NSW PLANNING ASSESSMENT COMMISSION

21 September 2009

Report on the Proposed Jacfin Warehouse Project

Figure 2 – Preliminary Layout Plan

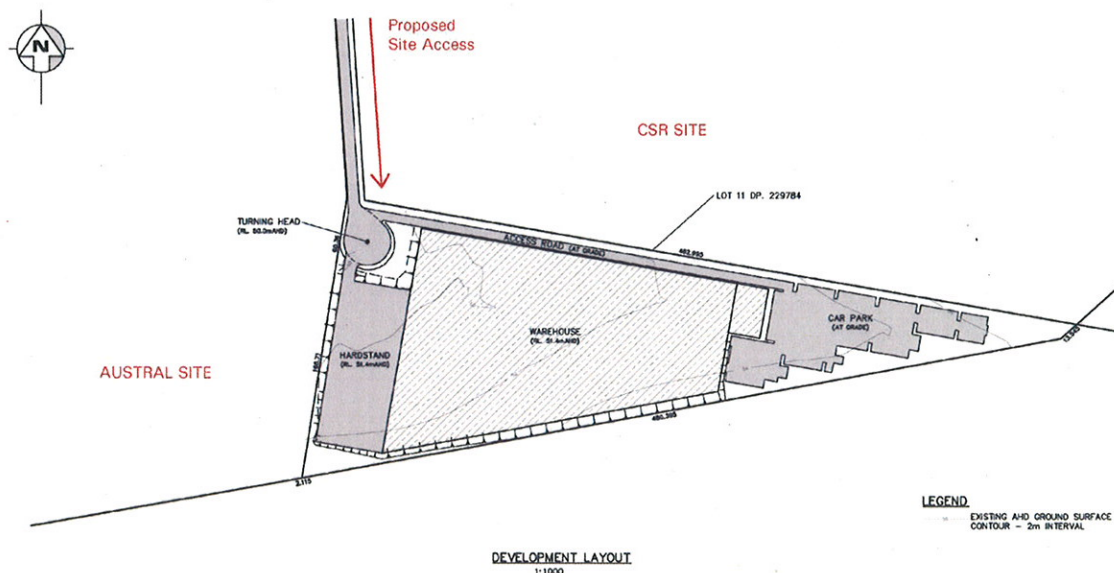
On balance the Commission considers it appropriate to seek to achieve a width approaching 100m, to the extent feasible without unduly compromising development, for the biodiversity corridor where it passes the Jacfin site. The Commission also notes that the narrow section of the corridor as it passes to the north of the Jacfin land is about 250m long and that sections which open out significantly lie immediately to the east and west of this 'throat'.

The Commission considers an alternative layout could take advantage of the triangular shape of the Jacfin site and enhance the biodiversity corridor, without requiring excessive sacrifice of developable land. In principle the triangular apex could be removed from the northern part of the site with the resultant shape becoming a four-sided figure, either an irregular trapezoidal shape or an irregular quadrilateral. This would enhance the corridor width in the most effective manner in terms of width-for-land-given-up.

The Commission considers that re-design along these lines would represent a better compromise between conservation and development than the design as proposed.

As the Commission has concluded that the biodiversity corridor should be widened in this area, it will be necessary either to relocate the cul-de-sac head to the south out of the biodiversity area or remove it completely. The Commission was unable to ascertain the need for a cul de sac in this area in view of the extensive manoeuvring areas to the south adjacent to the warehouse. It could be possible that the cul de sac head could be removed from the plans.

The road within the biodiversity area should be a maximum of 11m wide. An additional crossing for terrestrial wildlife should be provided in the biodiversity corridor equivalent in distance across the corridor to the proposed bridge over the creek. This can be either another bridge or a series of tunnels.

It is not appropriate for stormwater management facilities to be installed in a biodiversity corridor, especially one as constrained in width as that on the northern boundary of the Jacfin site. So any retention and treatment facilities should be installed on developable land on the site.
